Department of Primary Industries

OUT17/29236

Inland Rail Parkes to Narromine (SSI 7475) Comment on the Environmental Impact Statement

Inland Rail Parkes to Narromine (SSI 7475) DPI Water detailed comment on the Environmental Impact Statement

**Figure 8.2a**  
Construction work stages, work areas and compounds

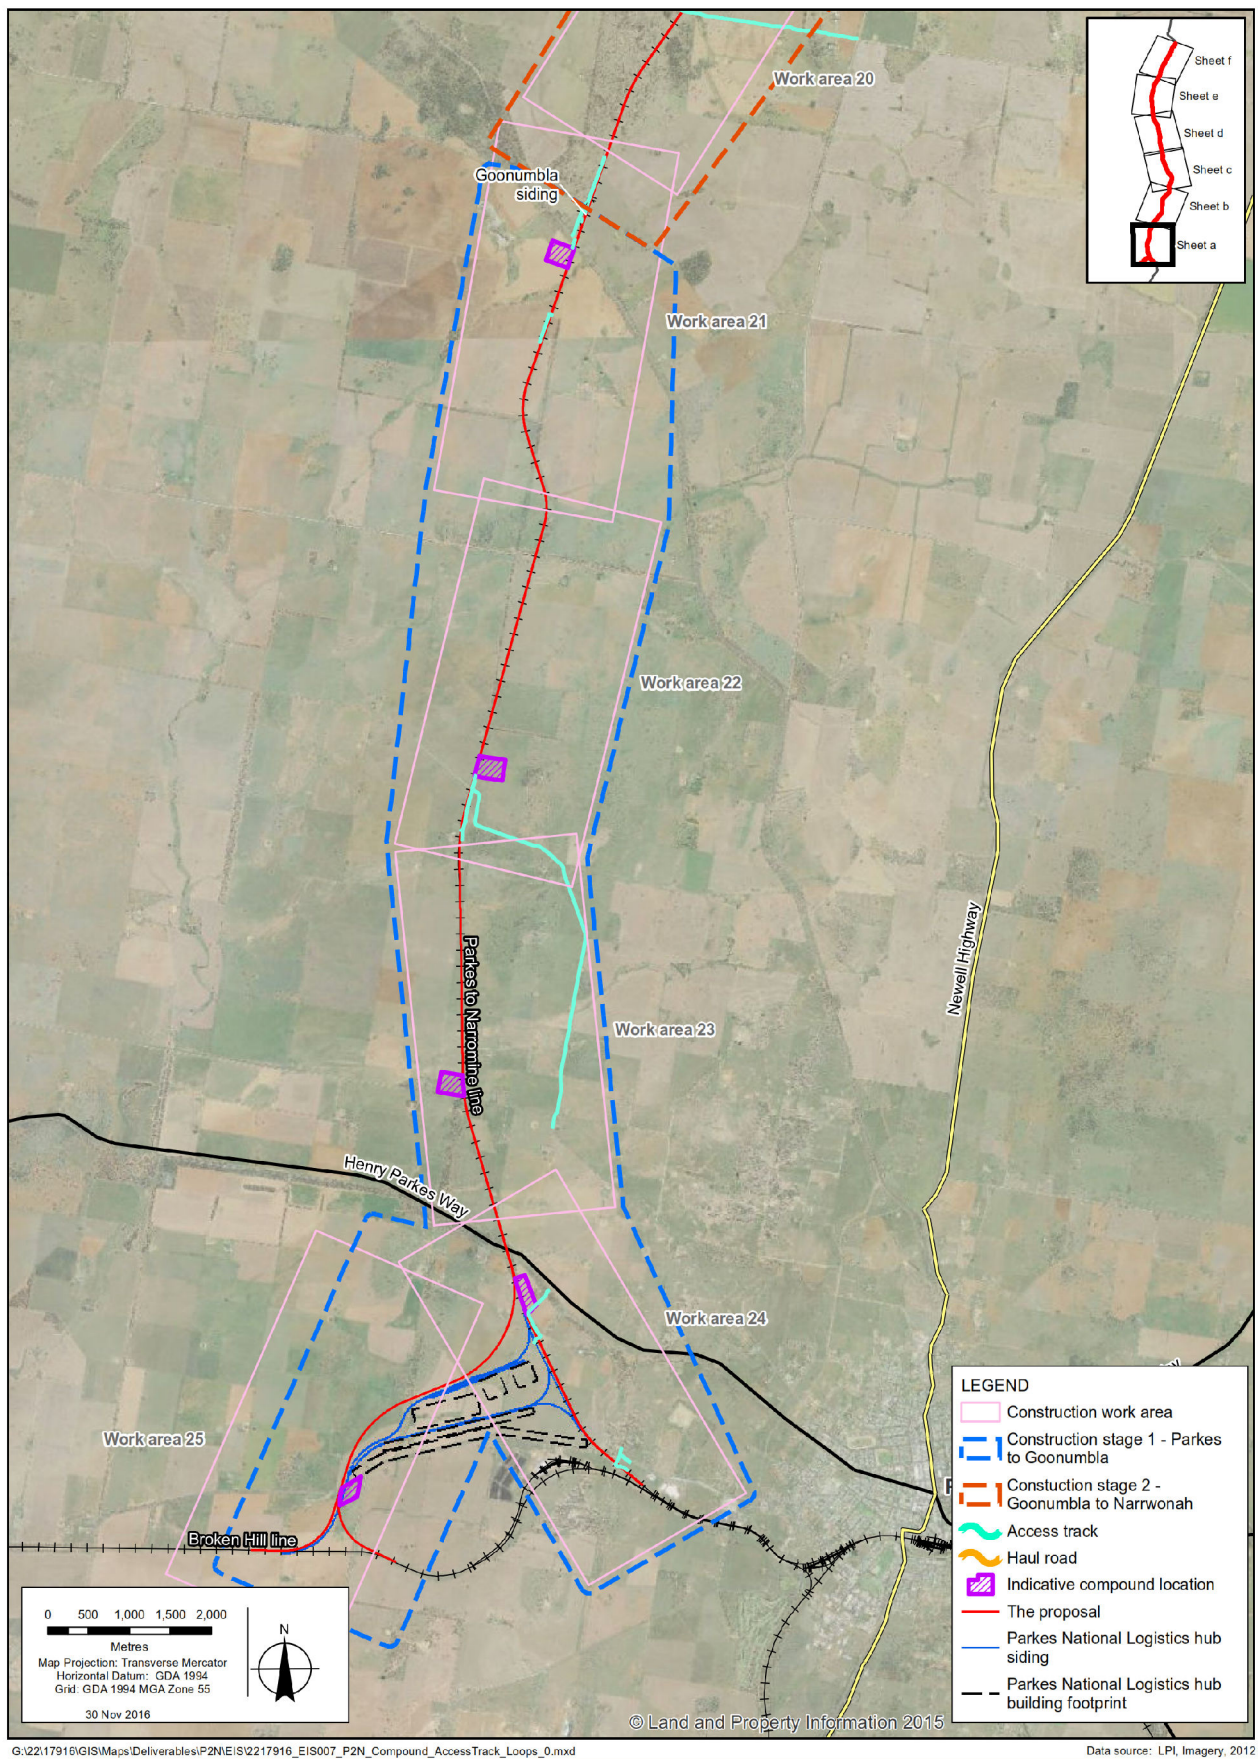
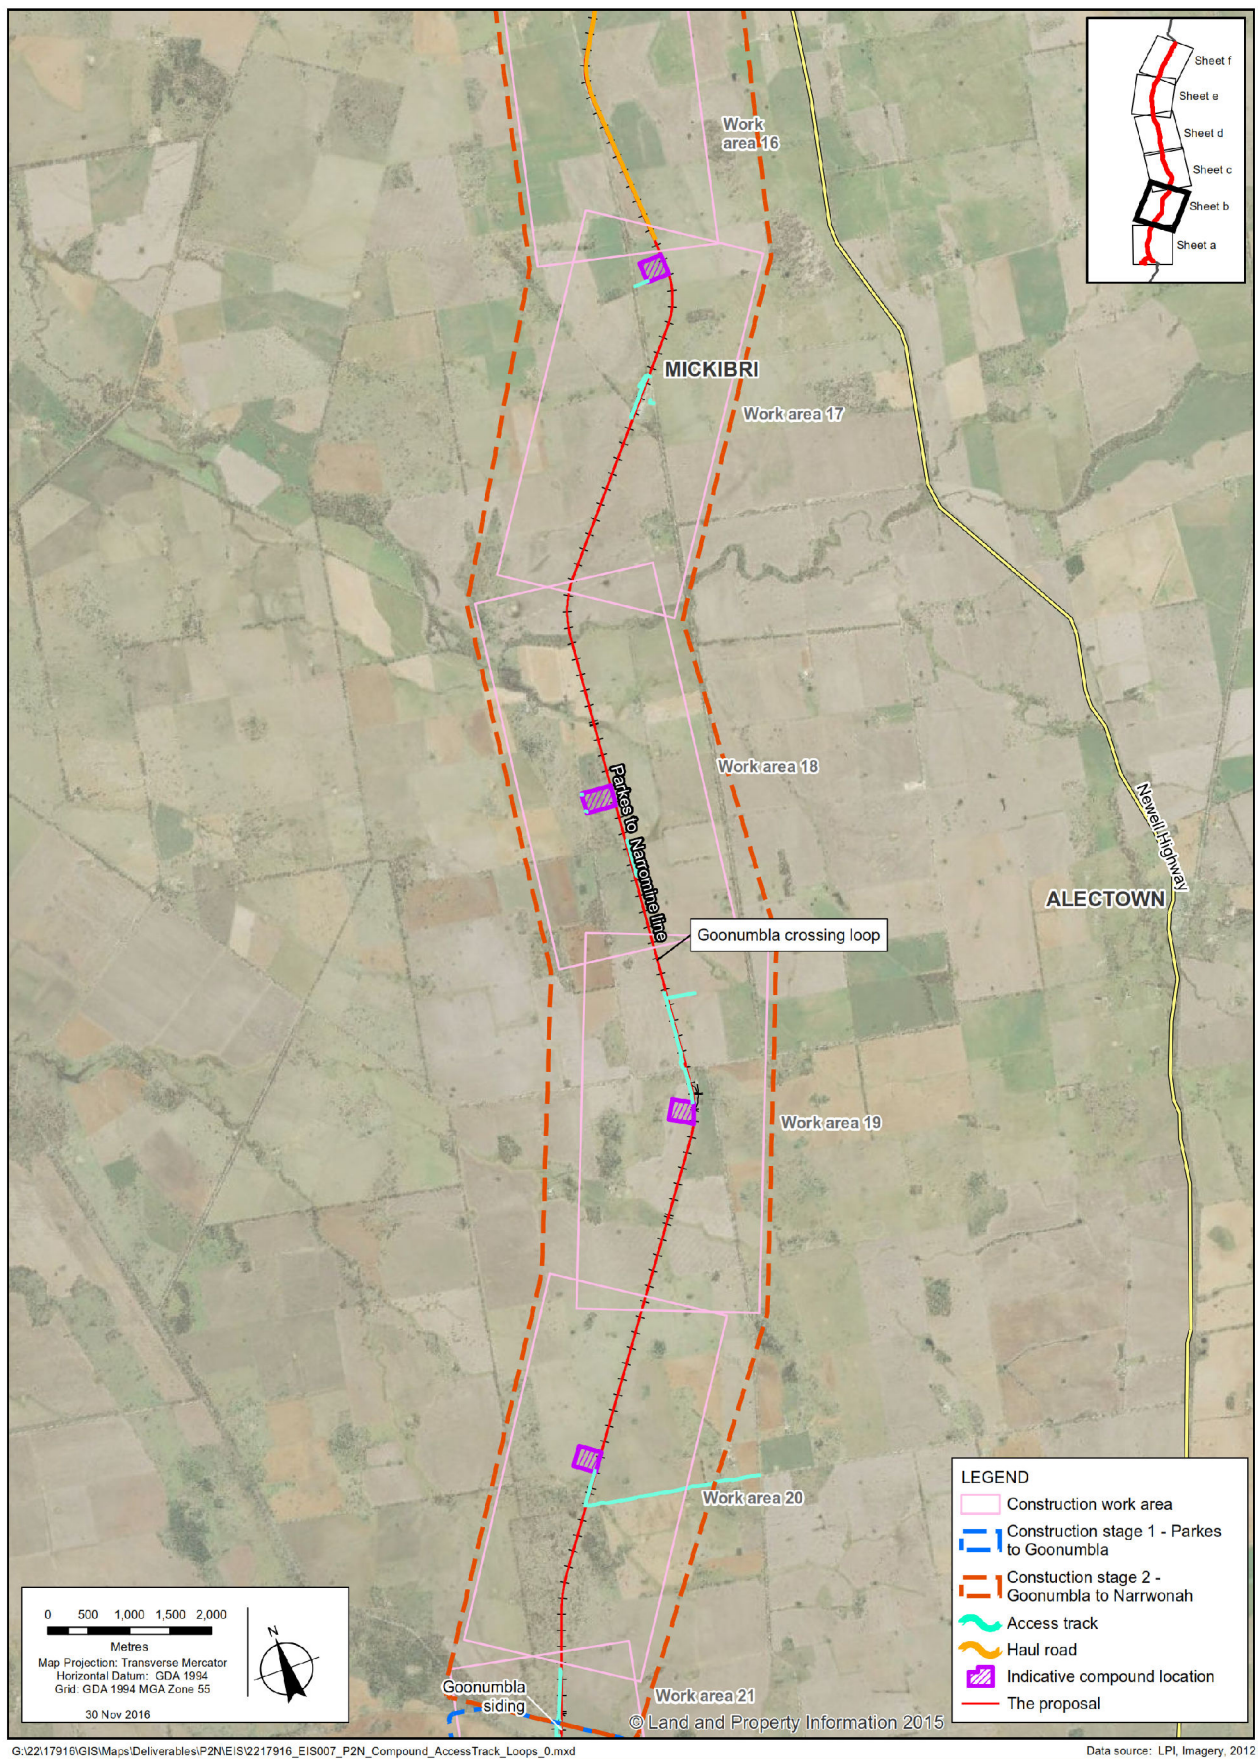
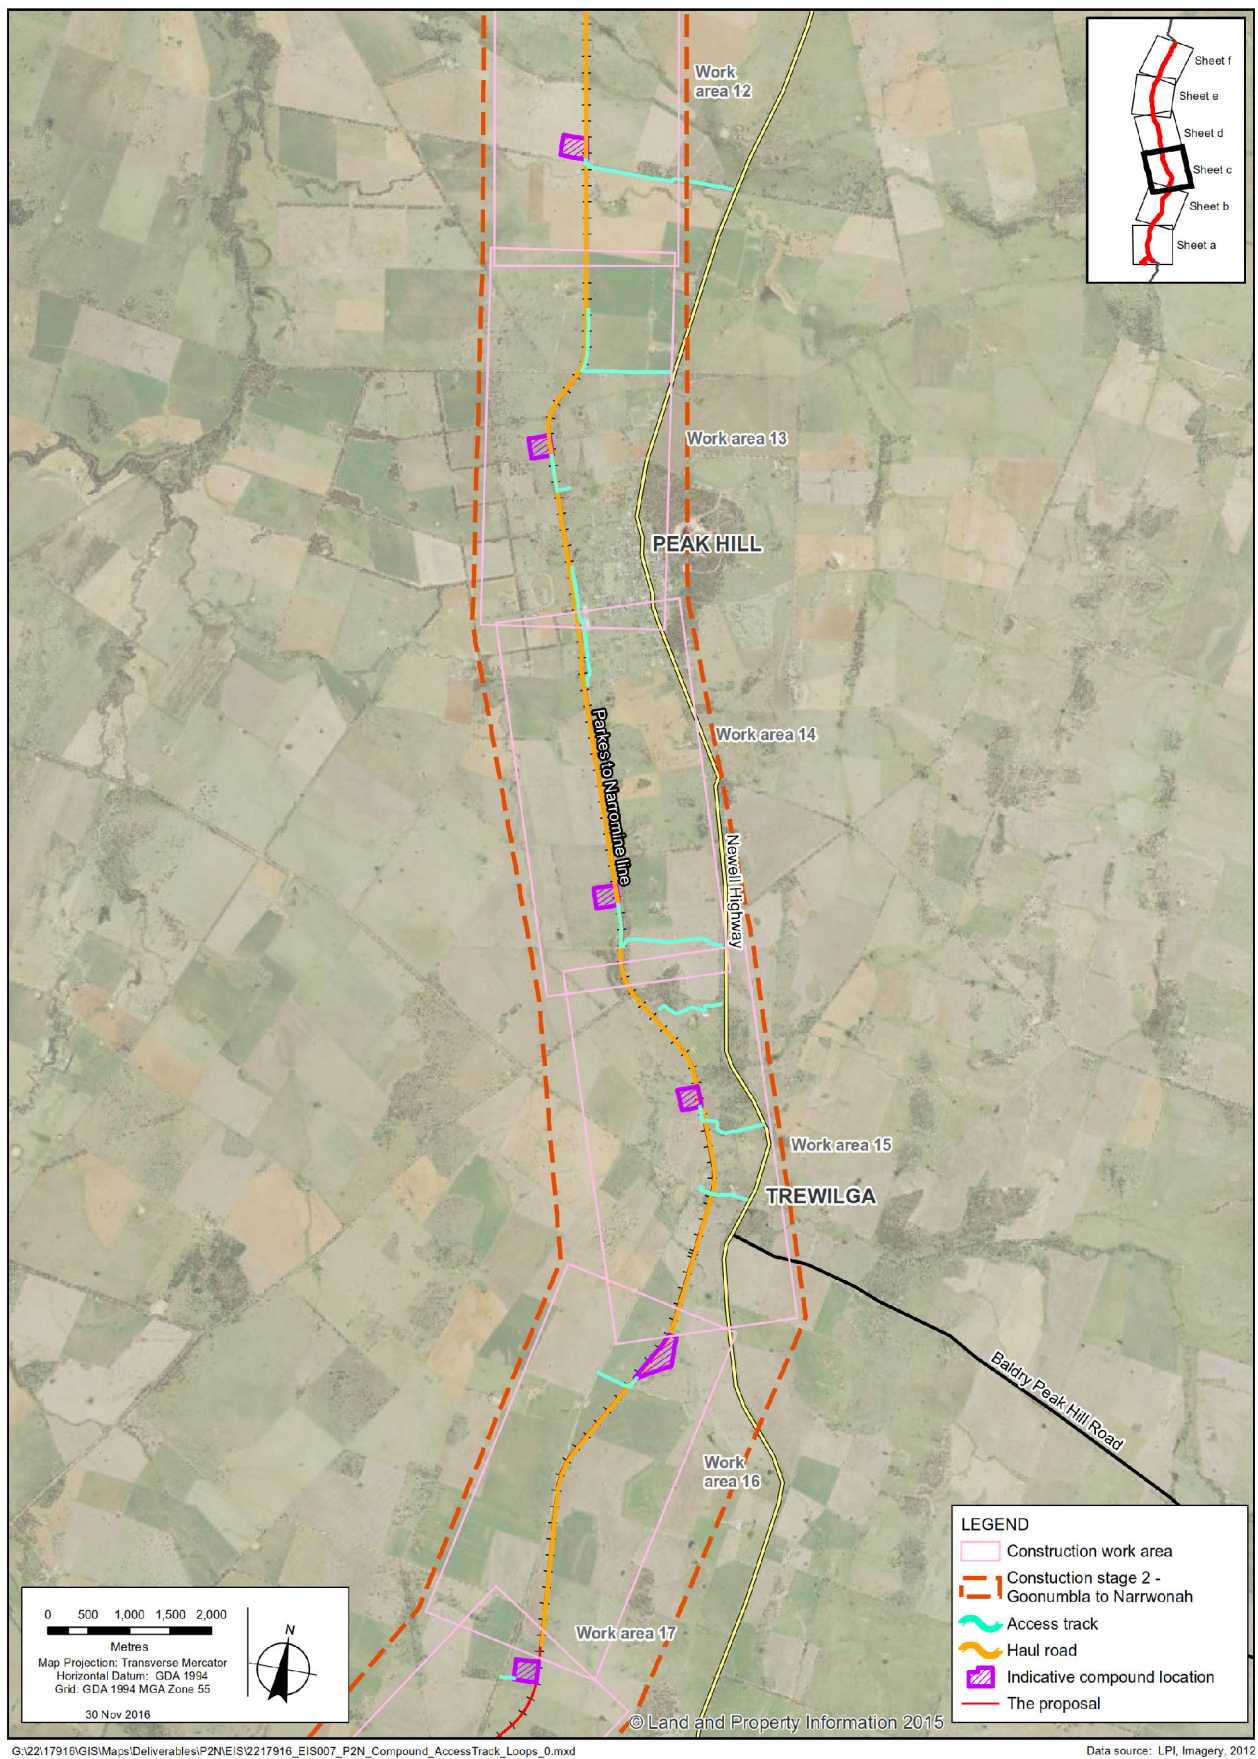
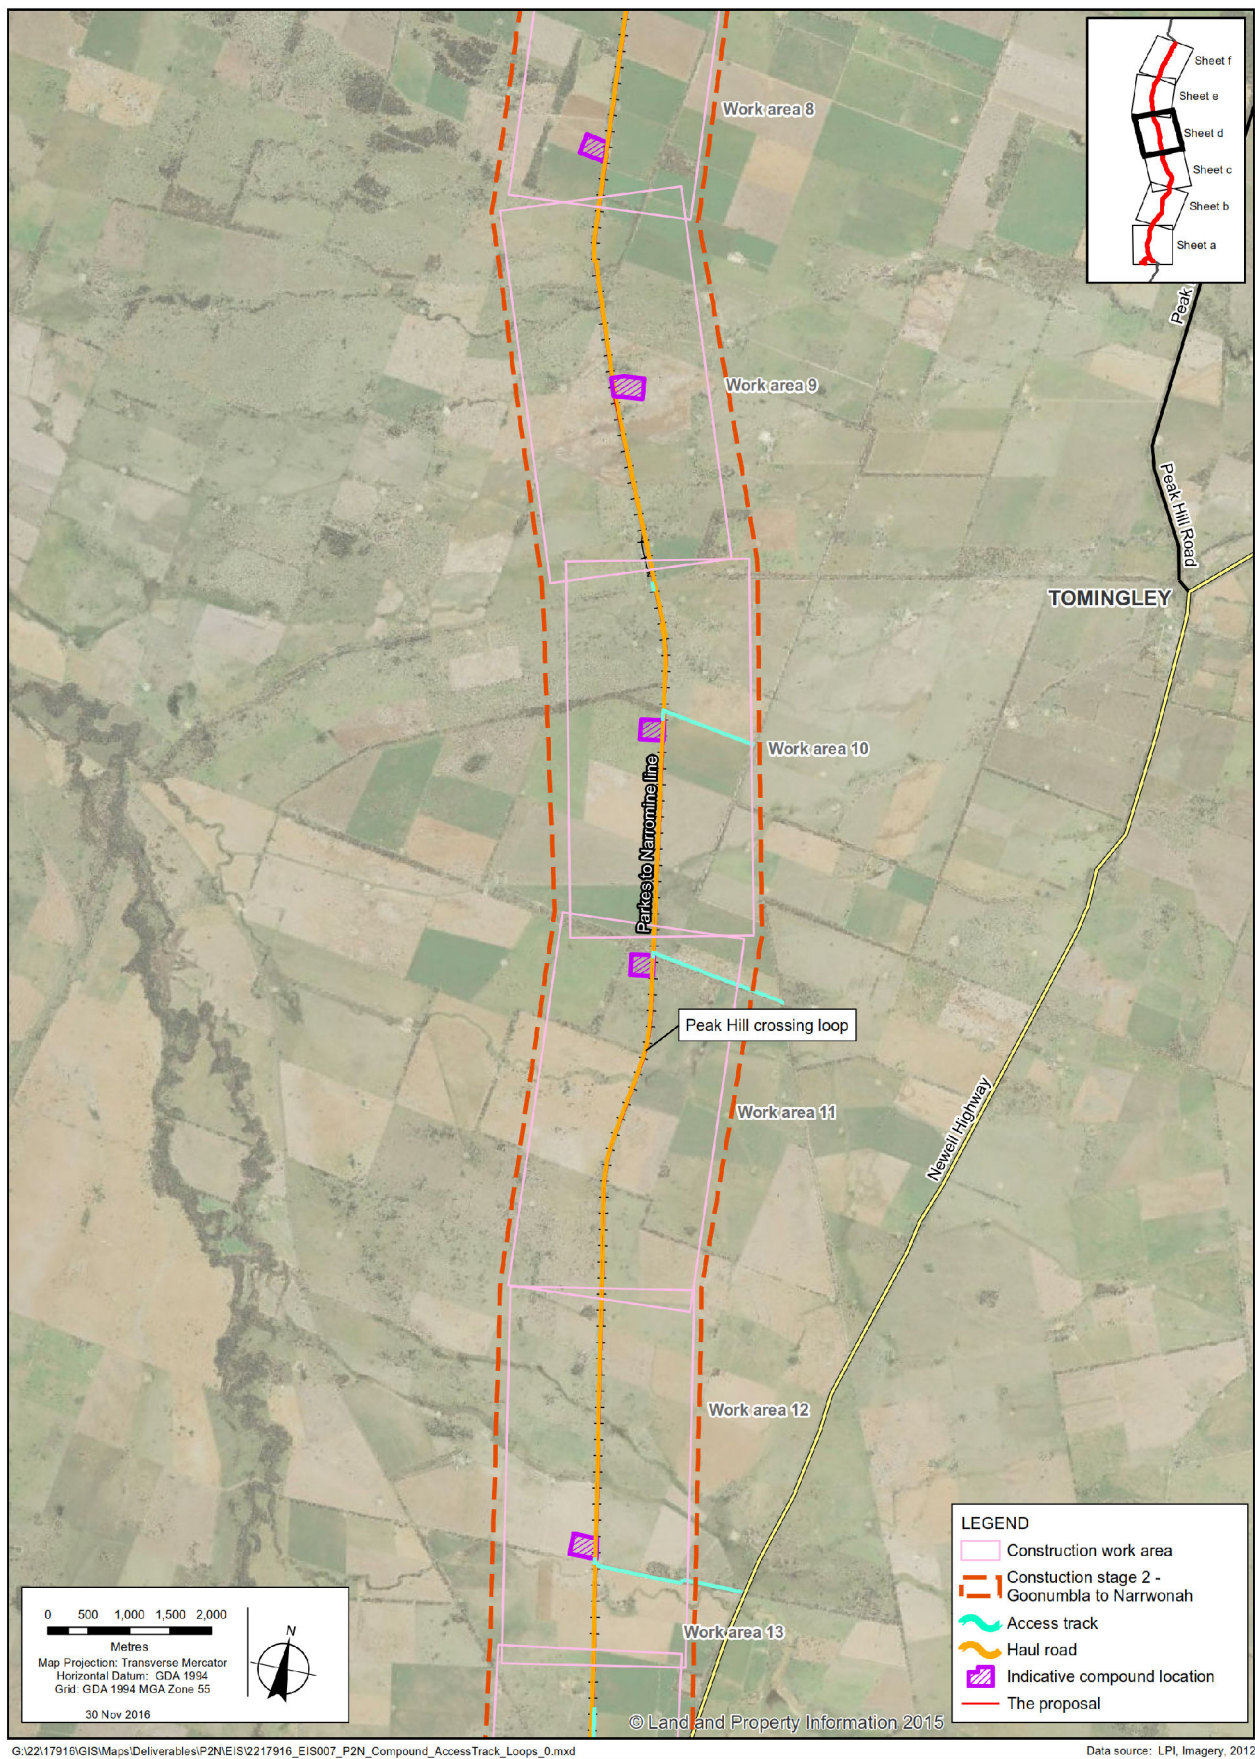
- Approximately 29 construction compounds are proposed along the rail route. Buffers from riparian vegetation have been developed based on fish habitat classifications with a 50m buffer for class 2 and 3 watercourses and 10 – 50m for other classes. DPI Water's buffers specified in the Guidelines for Controlled Activities on Waterfront Land (CAA Guidelines) are recommended as a mitigating measure to address watercourse stability and to maintain riparian vegetation.
